**Notice of Exhibition of application for Sydney Metro West- Rail infrastructure, stations, precincts and operations (SSI-22765520)**

Thank you for your referral dated 23 March 2022 inviting comments from the Heritage Council of NSW on the above State Significant Infrastructure (SSI) proposal.

Figure 15 Site plan - The Bays Station construction site

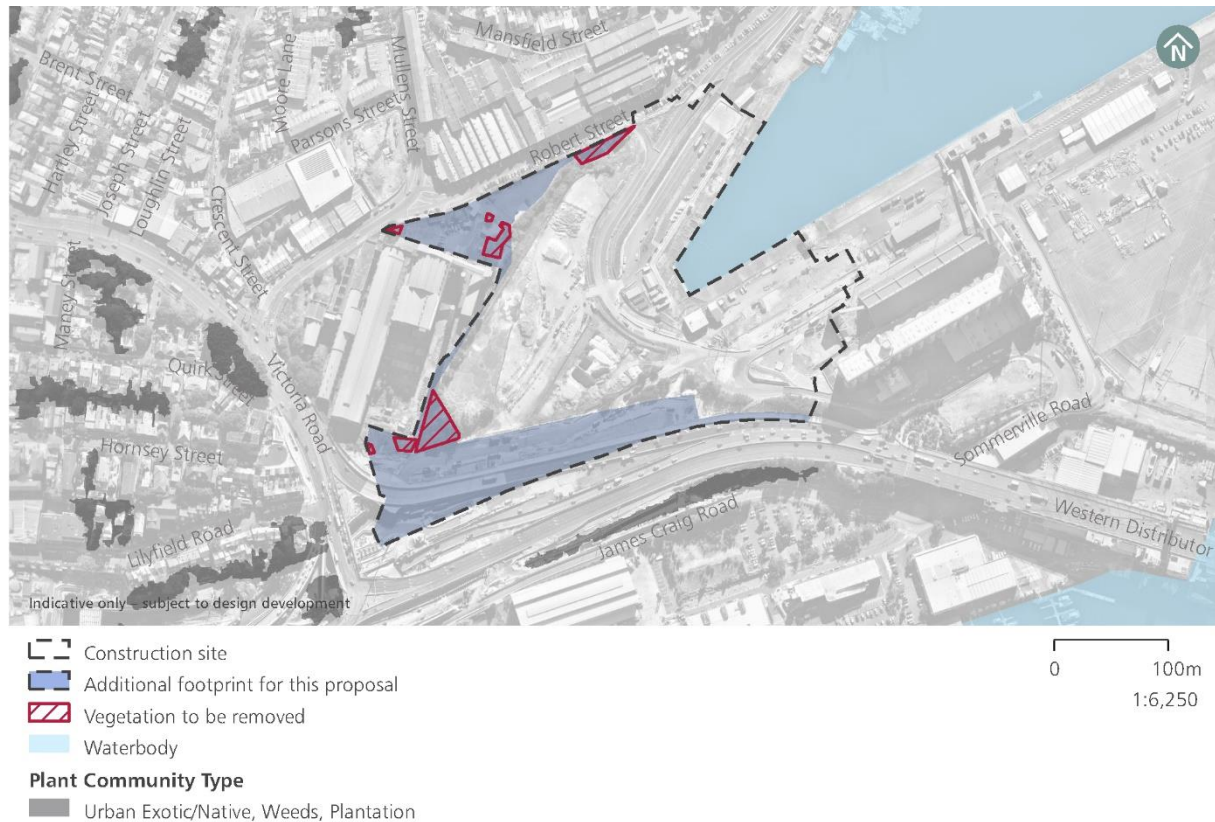
- The current expanded construction footprint as proposed for the Bays Metro Construction site would require the construction zone to extend further into the WBPS curtilage, which would further adversely impact the setting and context of the WBPS and potentially diminish its overall massing, configuration, and visibility. No mitigation

measures are proposed. Heritage NSW recommends that consideration be given to reducing the construction zone within the WBPS SHR curtilage.

- Heritage NSW agrees with the applicant's assessment that large parts of the construction site, including parts of the additional footprint areas as discussed in the supporting assessment, constitute land reclaimed in the 1850-70s (Artefact 2022, s. 11.5). Previous investigations of similar sites have shown that such areas have potential to contain archaeological remains of watercraft of potential State heritage significance (eg the Barangaroo boat);

- Such potential (including potential for maritime infrastructure and pre-1840s shipwrecks or parts thereof) has been identified as 'very likely' by recent assessments of adjacent sites (Cosmos Archaeology 2020, p. 87), however has not been discussed in the supporting assessment for this EIS; and

- Any future addendum ARDs and methodologies to be prepared for the management of archaeological relics within the additional footprints at The Bays Metro Station construction site should contain clear site-specific research including provisions and procedures pertaining to the management of maritime archaeological potential within the subject site.
